Application No: 20/03192/DISC-2

Proposal: Discharge of Condition 25 (Phasing), Condition 36 (Construction Management Plan), Condition 37 (Construction Environmental Management Plan for Biodiversity), Condition 38 (Tree Protection), Condition 39 (Training and Employment Plan) and Condition 45 (Site Access) and Partial Discharge of Condition 40 (Sustainable Drainage) and Condition 46 (Estate Roads, Parking and Turning Areas) of 19/01740/HYBRID

Location: Land Adj To Promised Land Farm, Wendlebury Road, Chesterton

Transport Development Control

PHASE 1 - PACKAGE 3
 ESTATE ROAD SETTING OUT PLAN

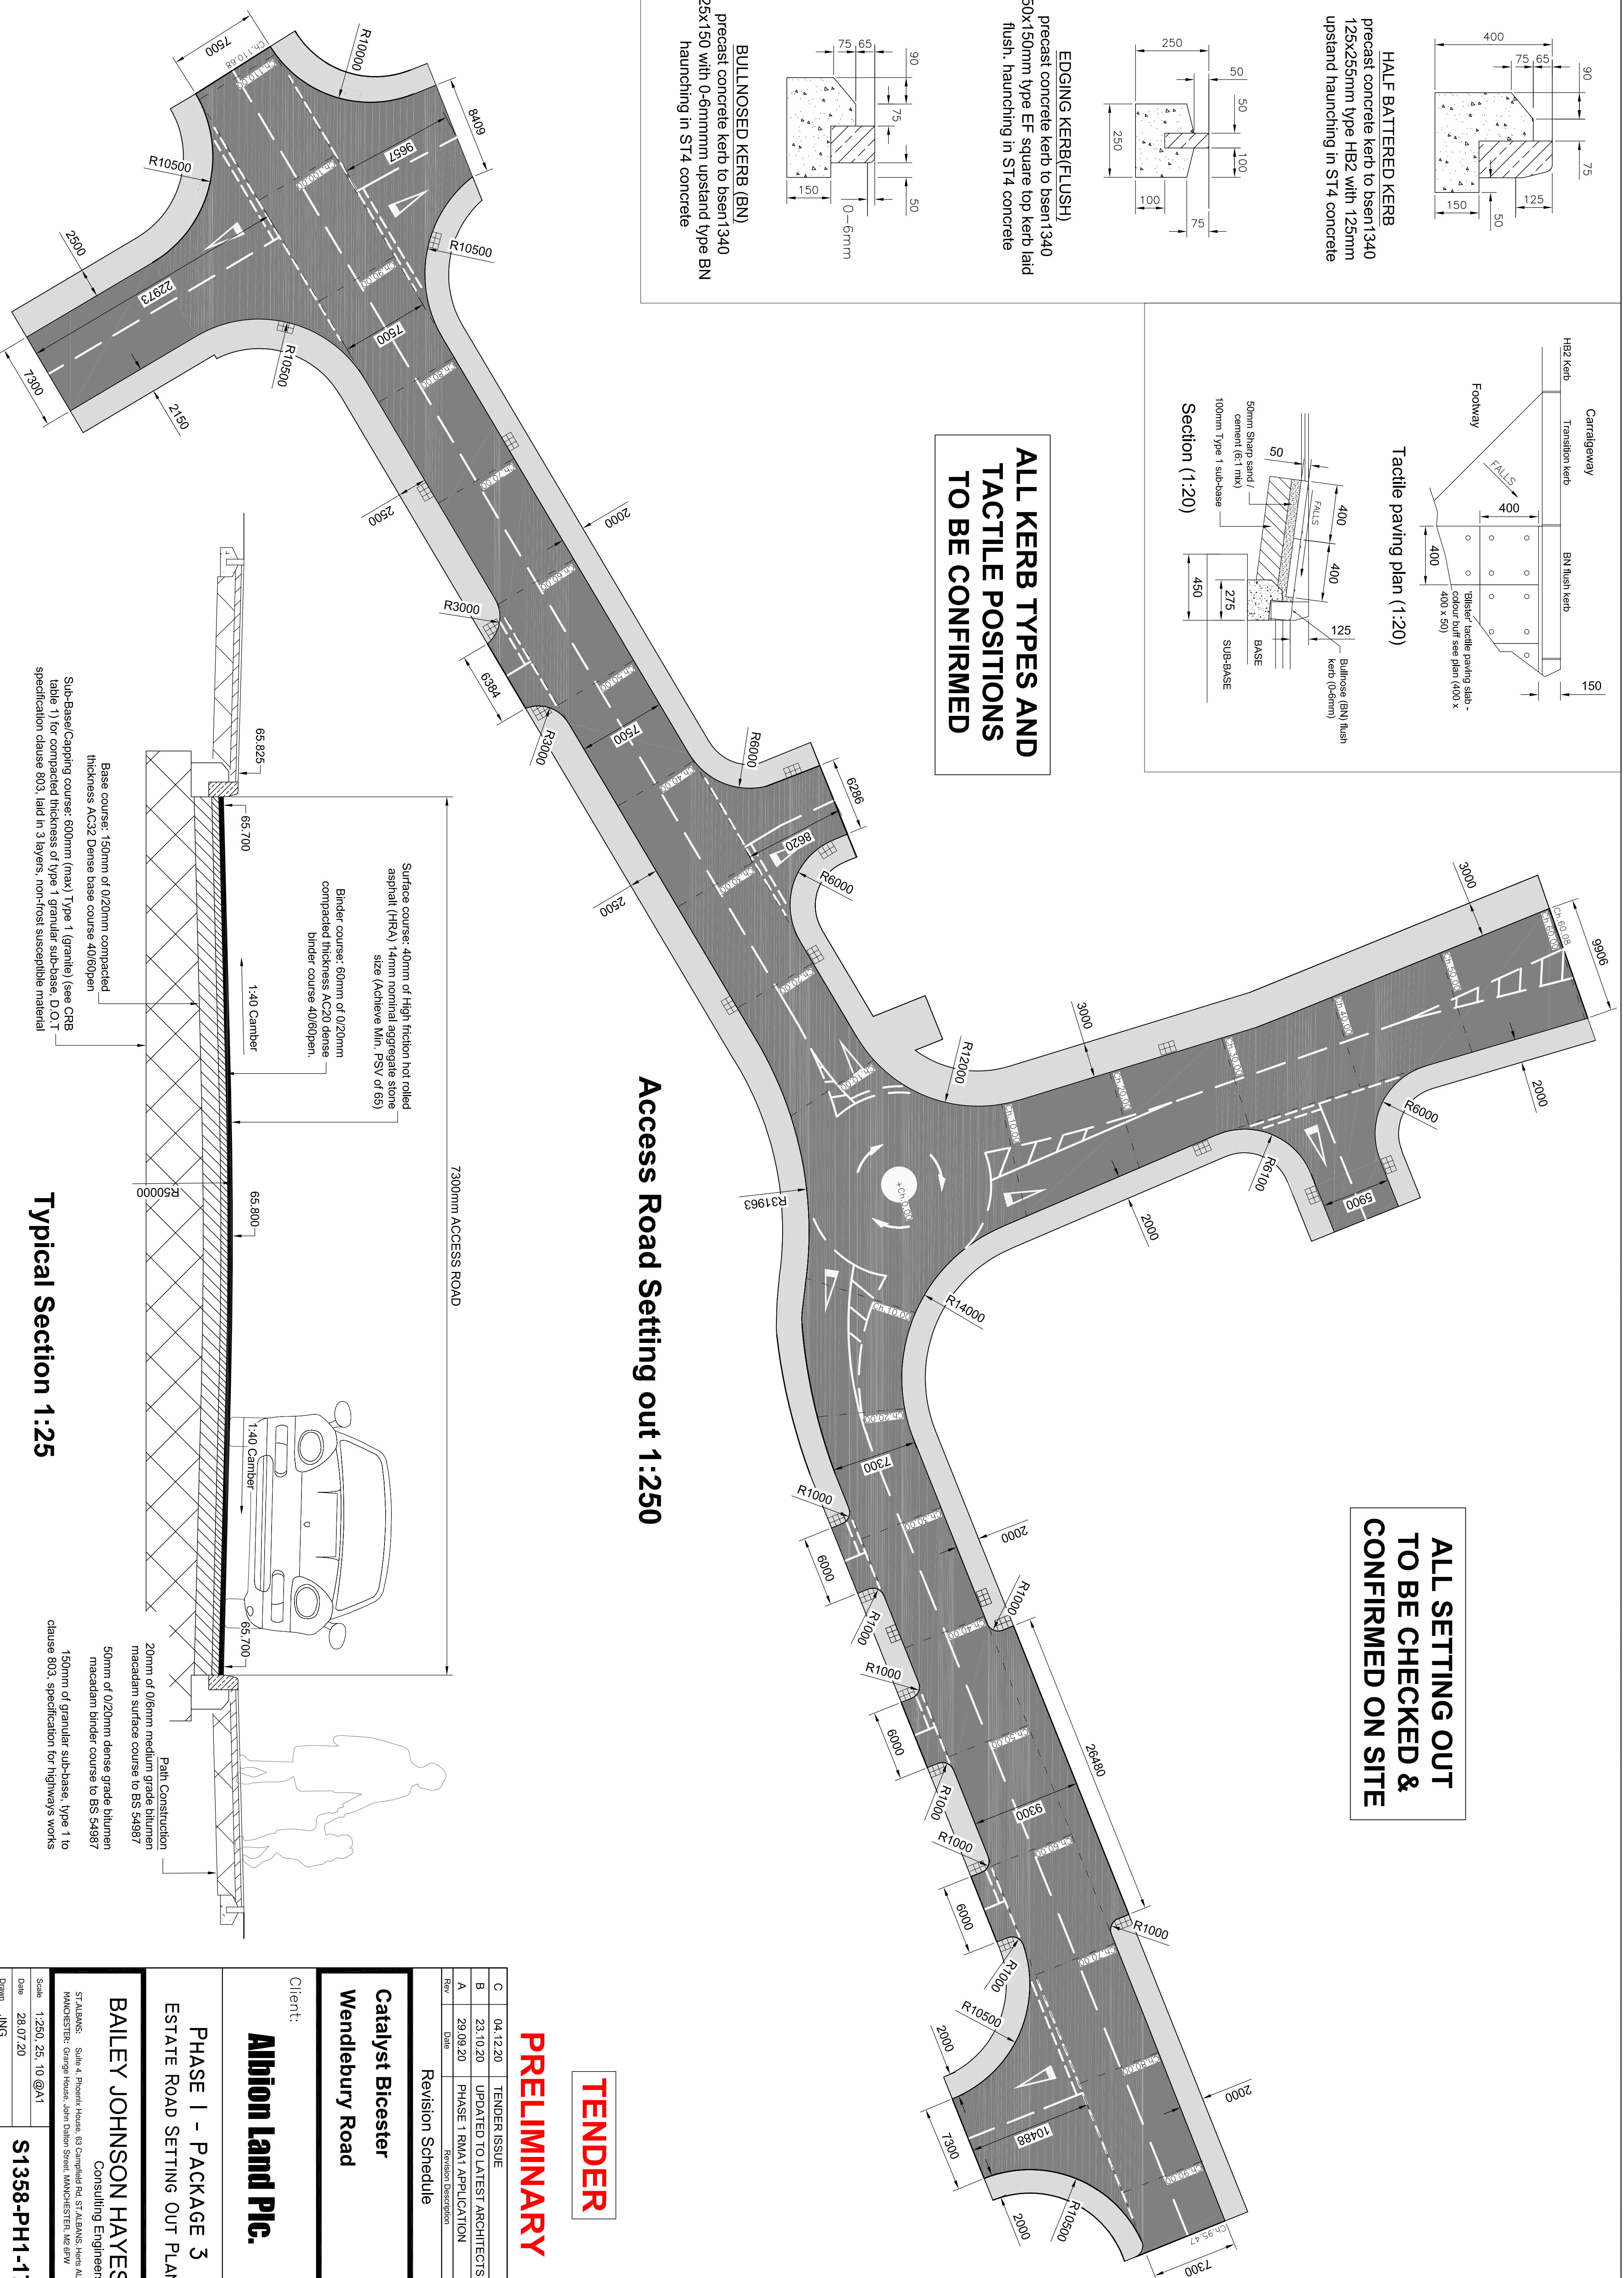
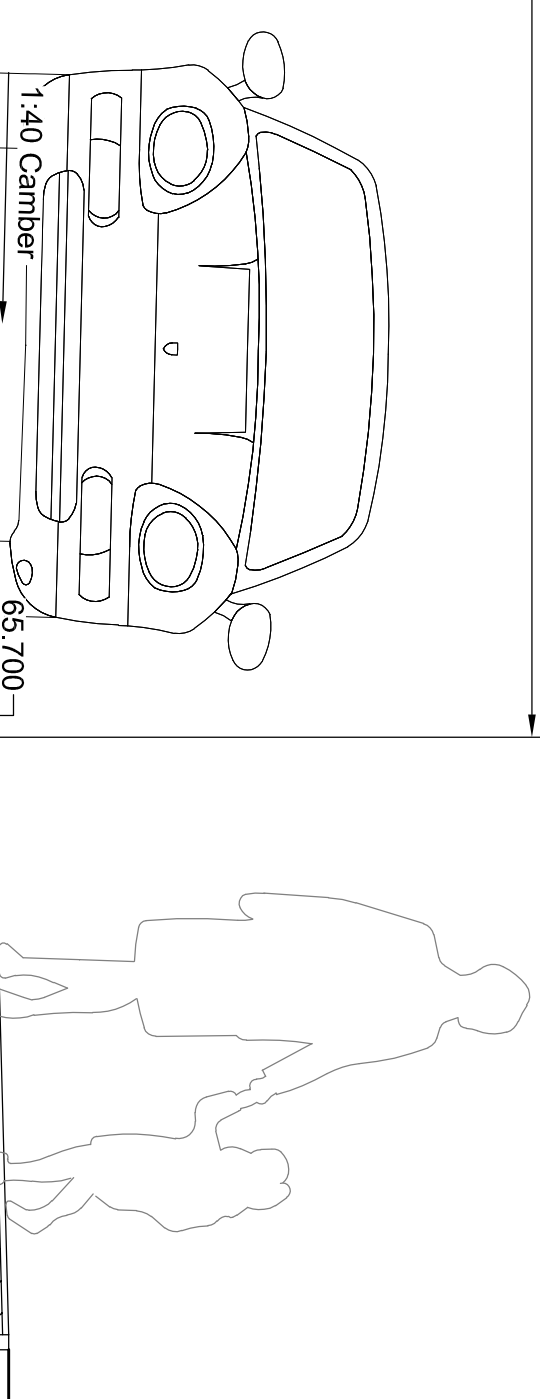
Conditions 46 – Objection

I also note that this submission has presented plans seeking to discharge the condition related to estate roads siting within the area of the outline part of the Hybrid application. It is my understanding that aspects of the estate roads, parking and turning areas that warrant review under a discharge of conditions are those within the David Lloyd estate. Any estate roads that form part of the employment of the Hybrid consent are expected to come through first via a reserved matters application.
